From: Paul McLaughlin [REDACTED]
Sent: 22 May 2015 12:17
To: 'Dominic Smith'
Cc: [REDACTED] Agency Dan McEwan; [REDACTED]
Subject: RE: Site east of Brook Lane/south of A259, Rustington - Ref: A/23/15/OUT

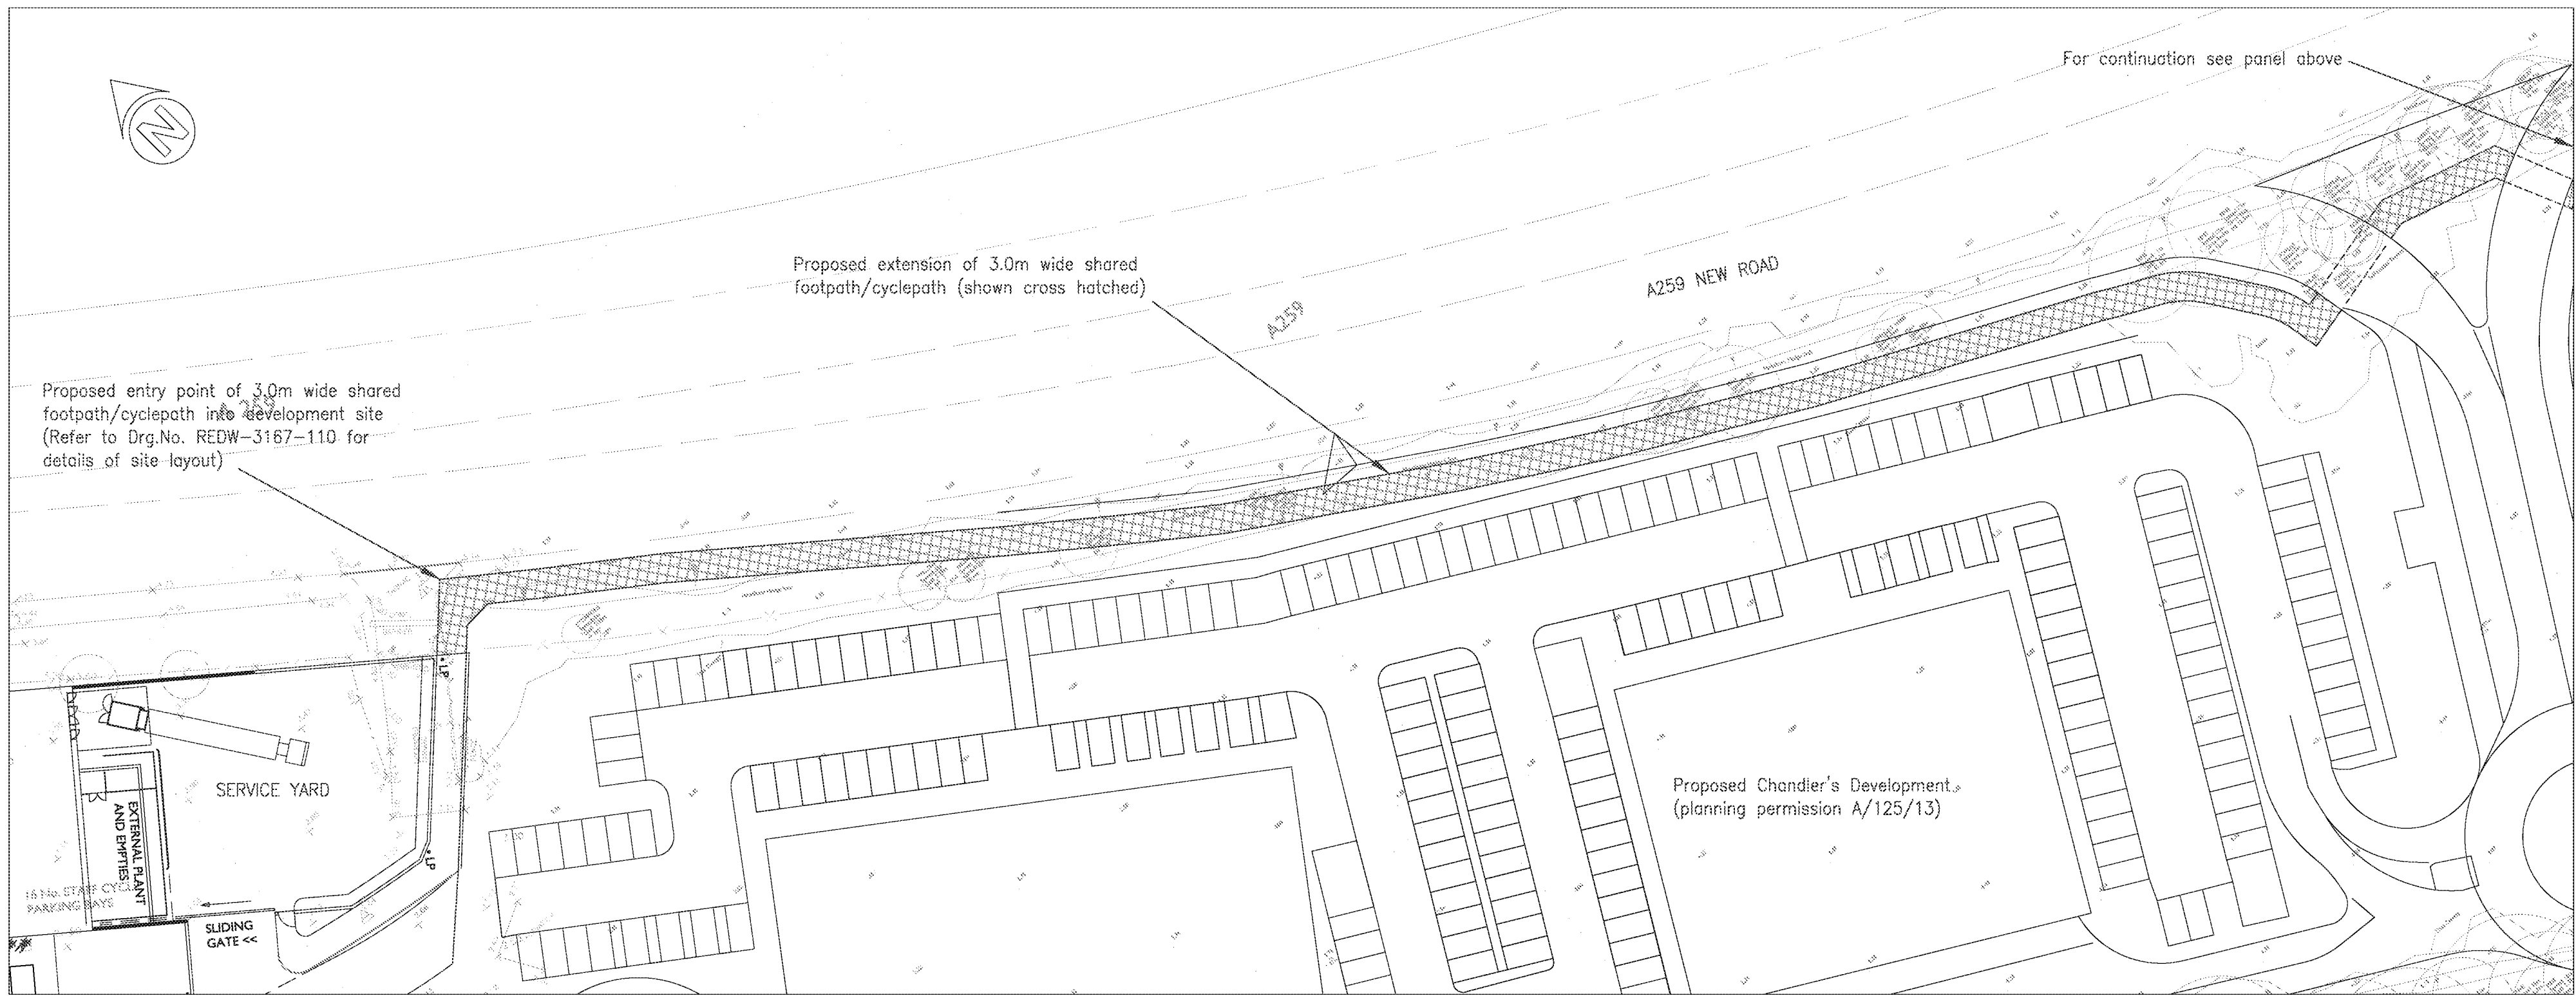
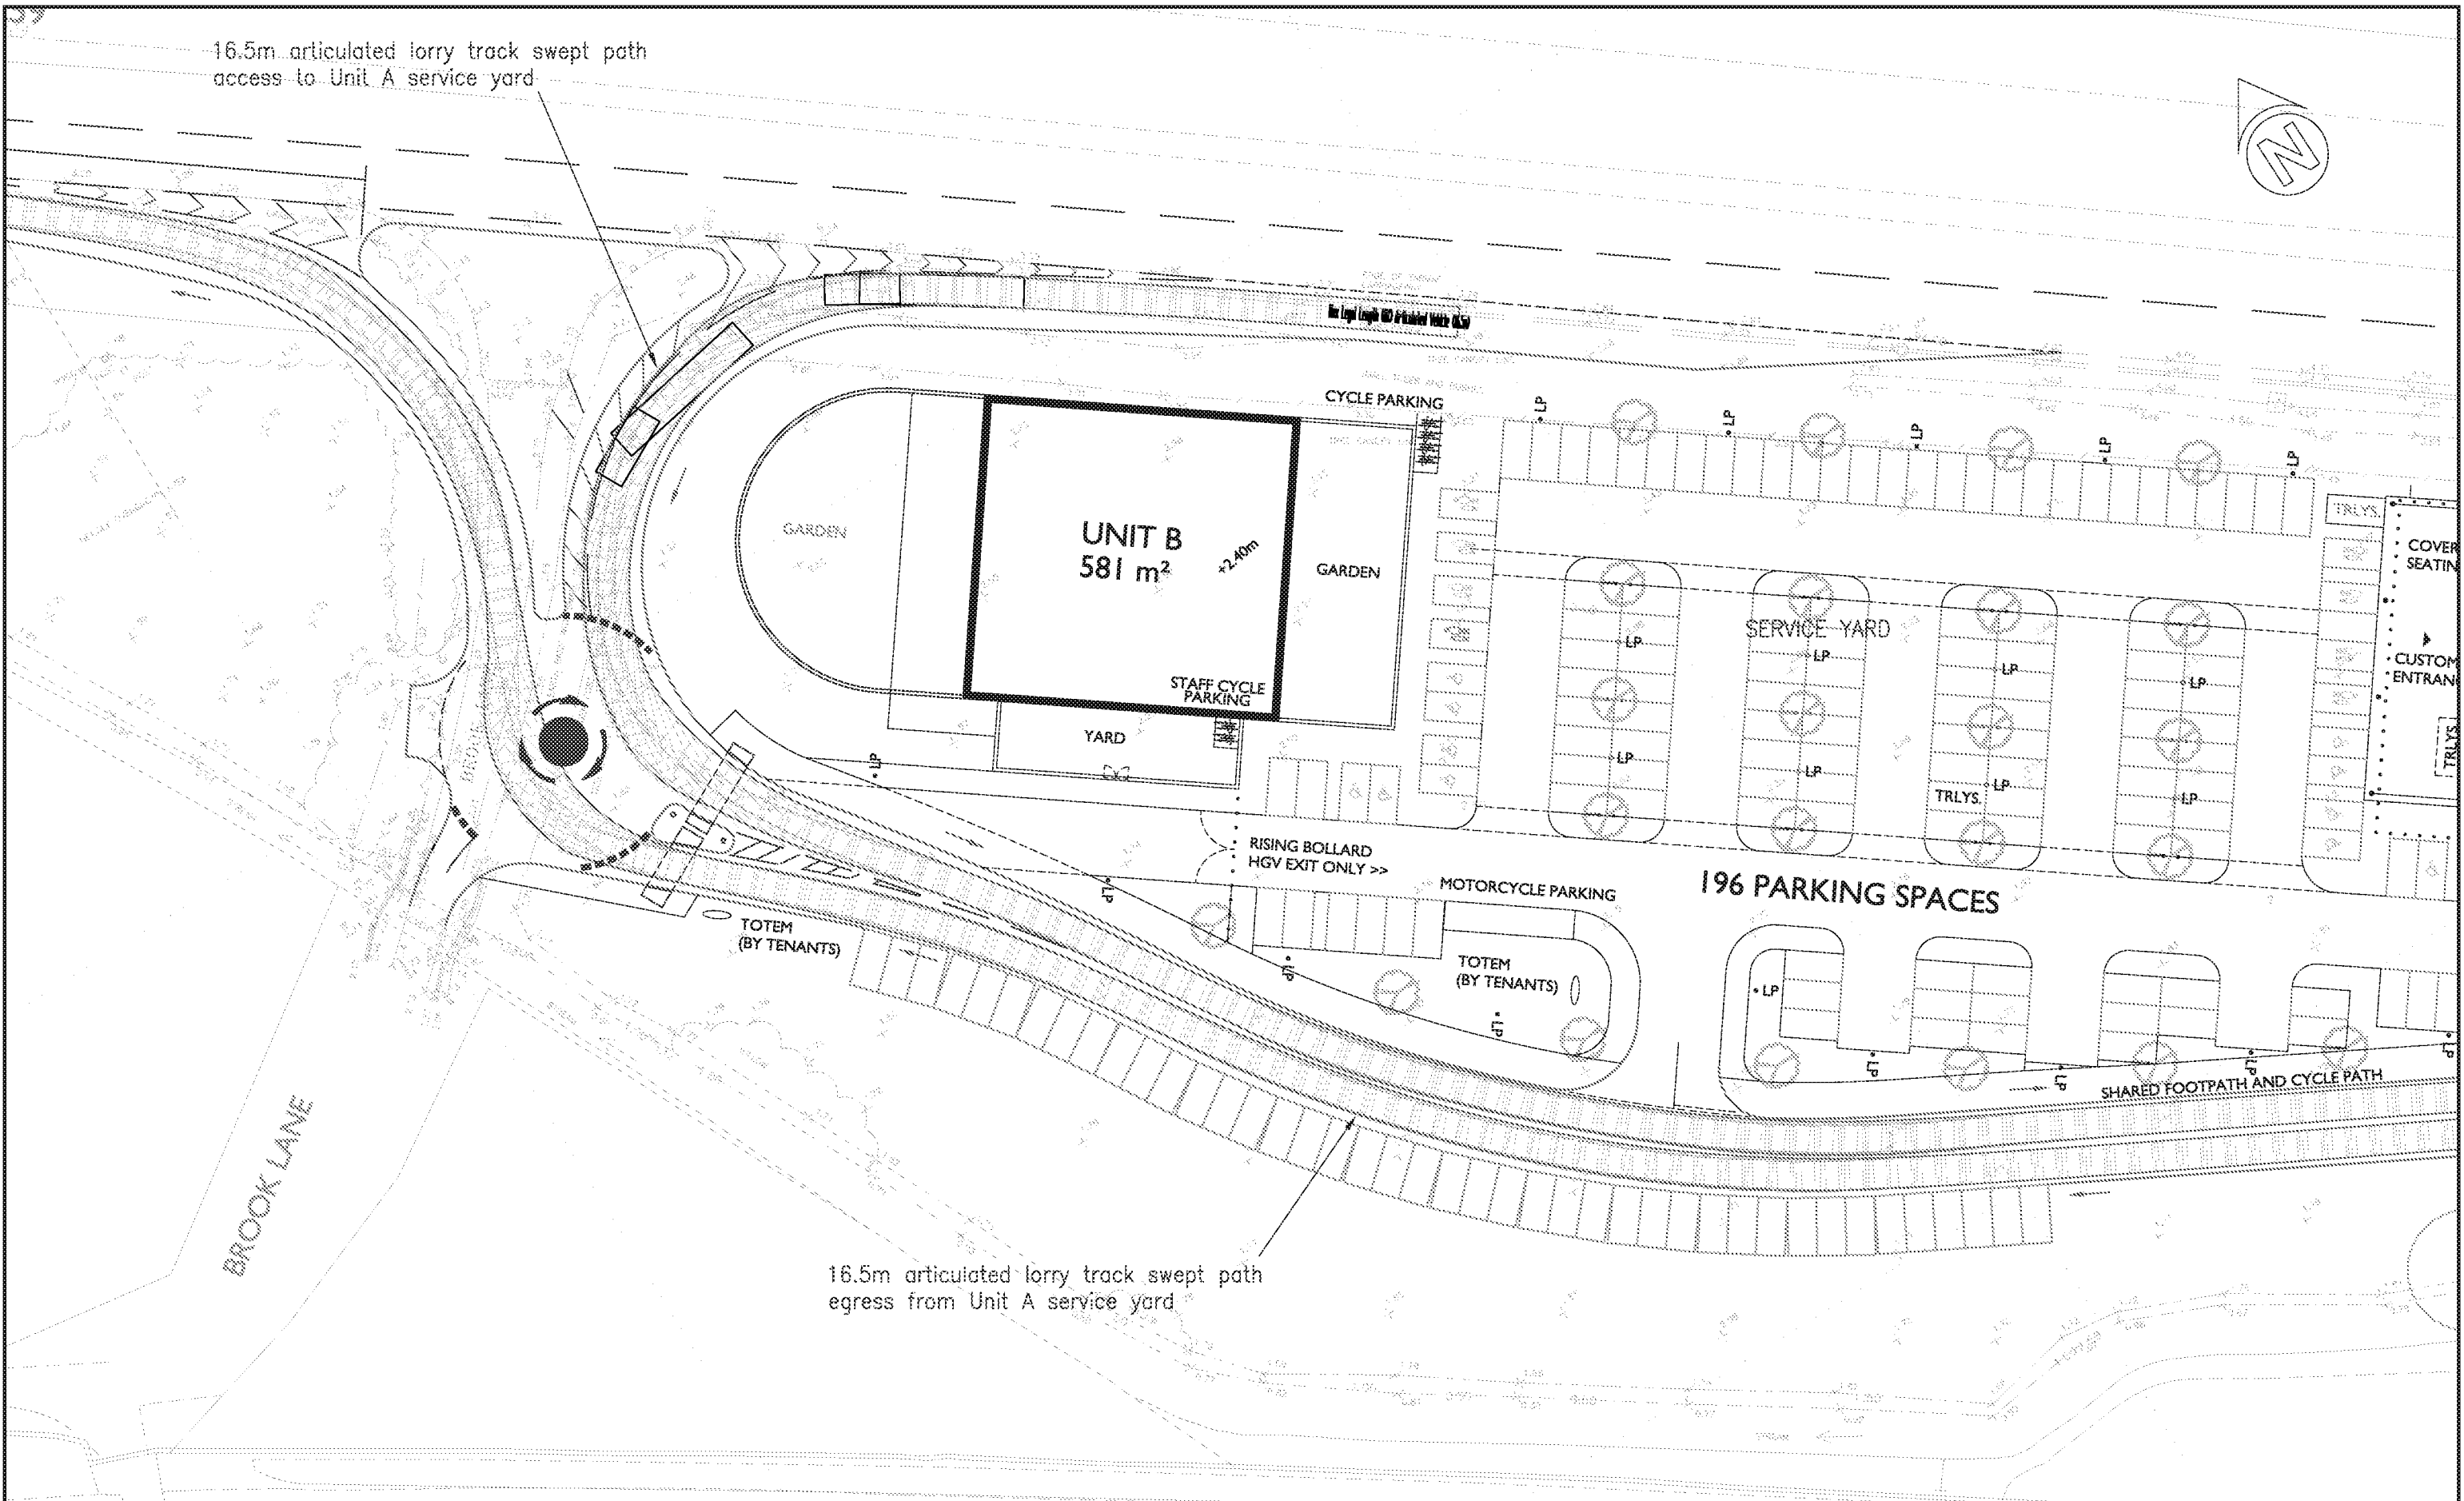
Proposed shared path should sit within highway; the approved S278 attached implies it will be necessary for some additional S38 land take and horizontal alignment alteration to get this back into existing highway land.

Mark – can I get your thoughts on the below? They want to extend the cycle/footway route and I assume the extent of the adoption will mean this is all in the highway boundary?

In advance of the application I attach for your information our drawing REDW-3167-111 which shows our understanding of the off-site works proposed by the Chandler's development. Importantly we intend to extend the footpath/cyclepath adjacent to the A259 New Road (shown cross-hatched). In this regard you mentioned that a s278 was being agreed, clearly we trust there will be sufficient s38 adoption on the site frontage to allow for this route through to our site without requiring 3rd party land. The existing verge is quite wide so I expect you would look to reinstate the same width as new verge around the Chandler's site access
